Application Ref:	3/2026/0354			 Ribble Valley Borough Council www.ribblevalley.gov.uk
Date Inspected:	26/06/26	Site Notice:	26/06/26	
Officer:	AR			
DELEGATED ITEM FILE REPORT:				
				APPROVAL

Development Description:	Proposed demolition of existing side extension and rear conservatory. Construction of new two-storey side extension and single-storey rear extension.
Site Address/Location:	13 Brookside Old Langho BB6 8AP

Proposed Site Plan

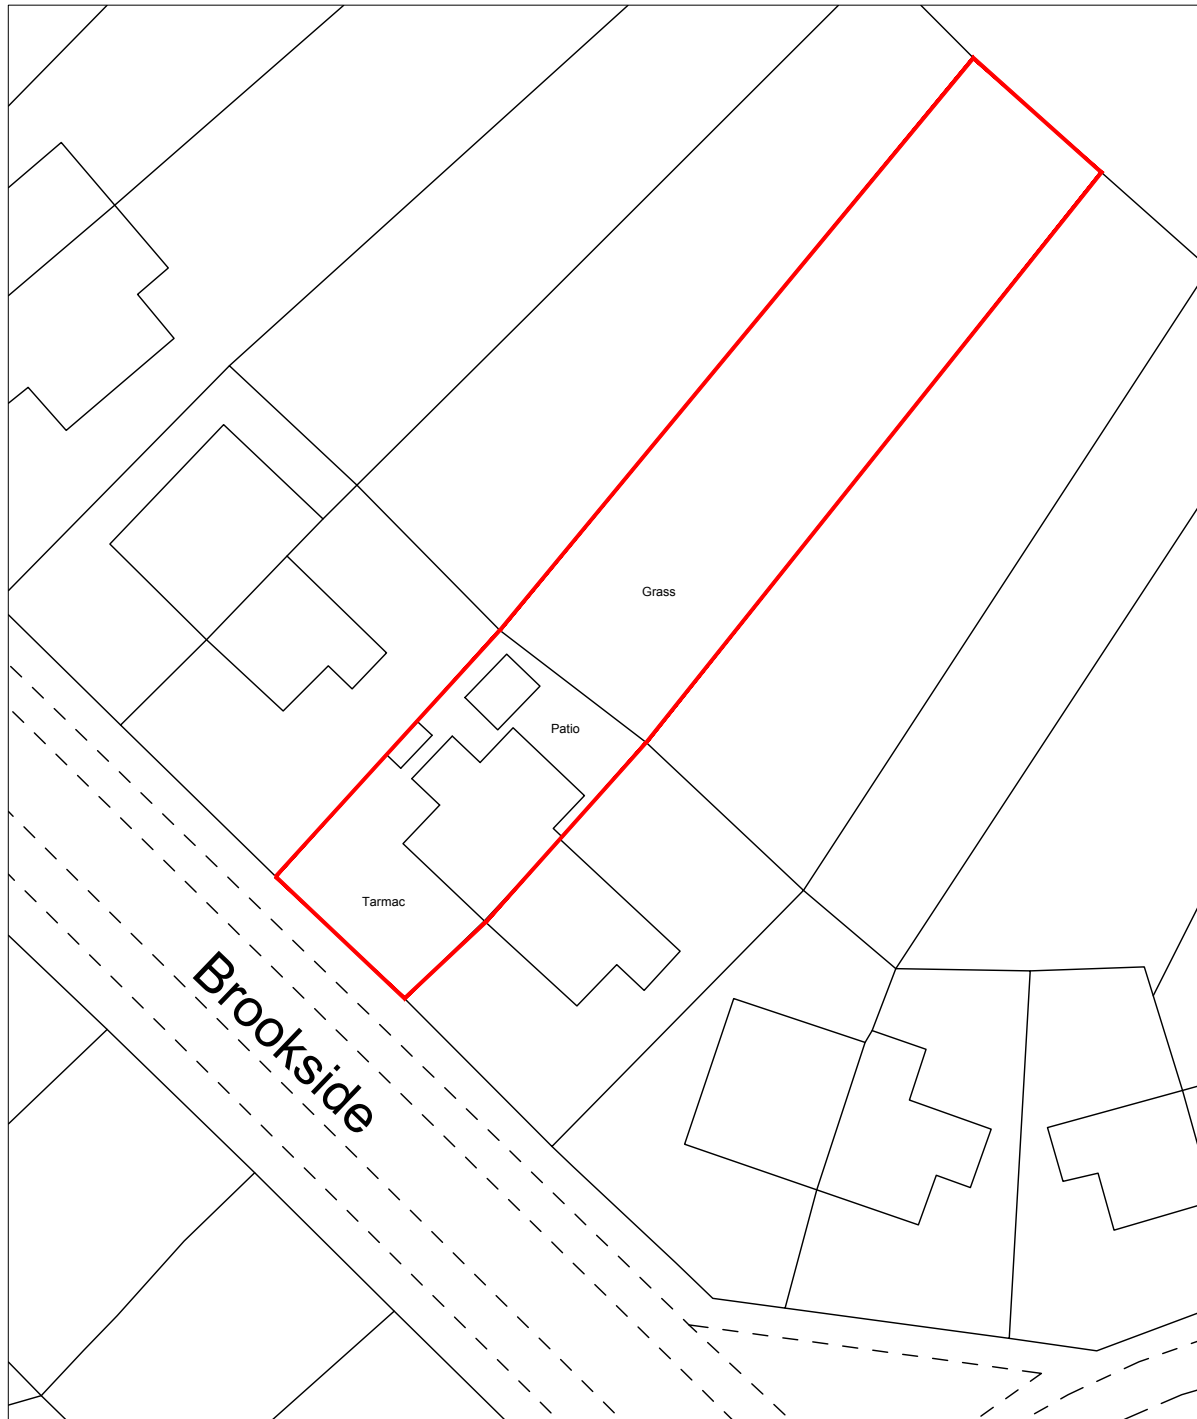
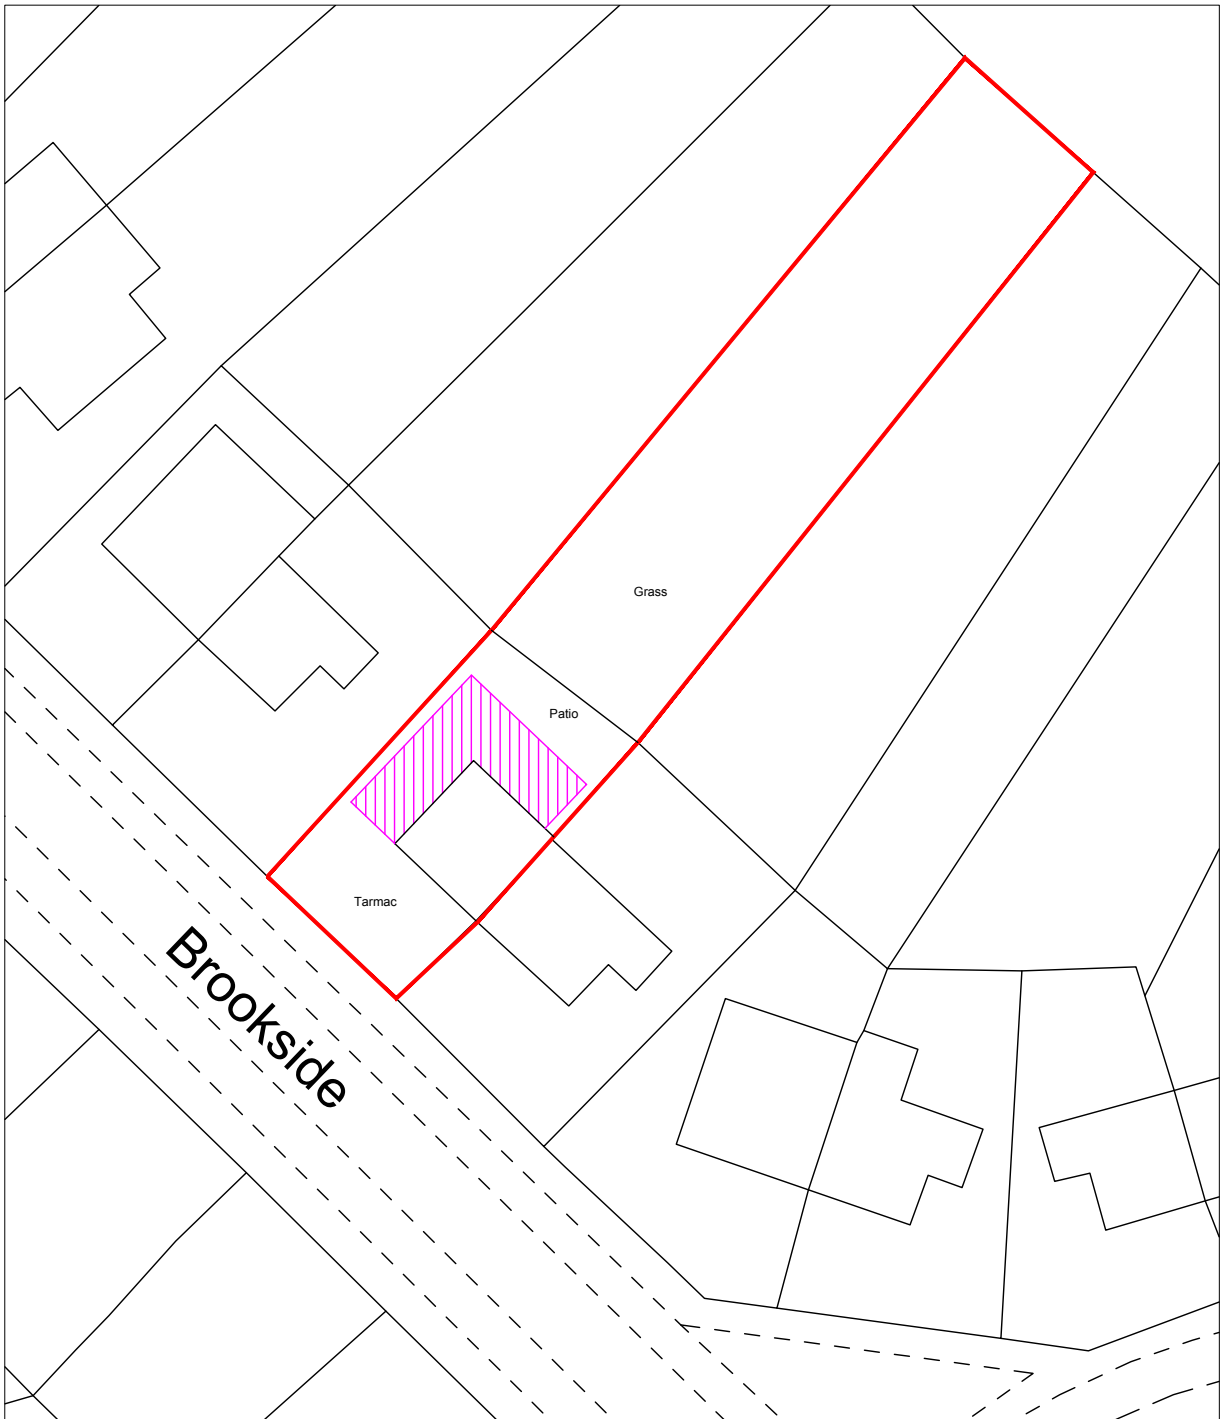
CONSULTATIONS:	Highways/Water Authority/Other Bodies
LCC Highways:	No objections to the proposal, provided a parking plan is submitted to the LPA demonstrating that 3 standard parking spaces can be provided within the curtilage of the property.

LCC Highways has reviewed this application and raises no objection to the proposed development, subject to a parking plan being submitted demonstrating that the 3 parking spaces required by parking standards can be provided within the curtilage of the property. Subsequently, these three standard parking spaces have been shown on the ‘existing and proposed site plans’ drawing ref: HA26008-02-B.
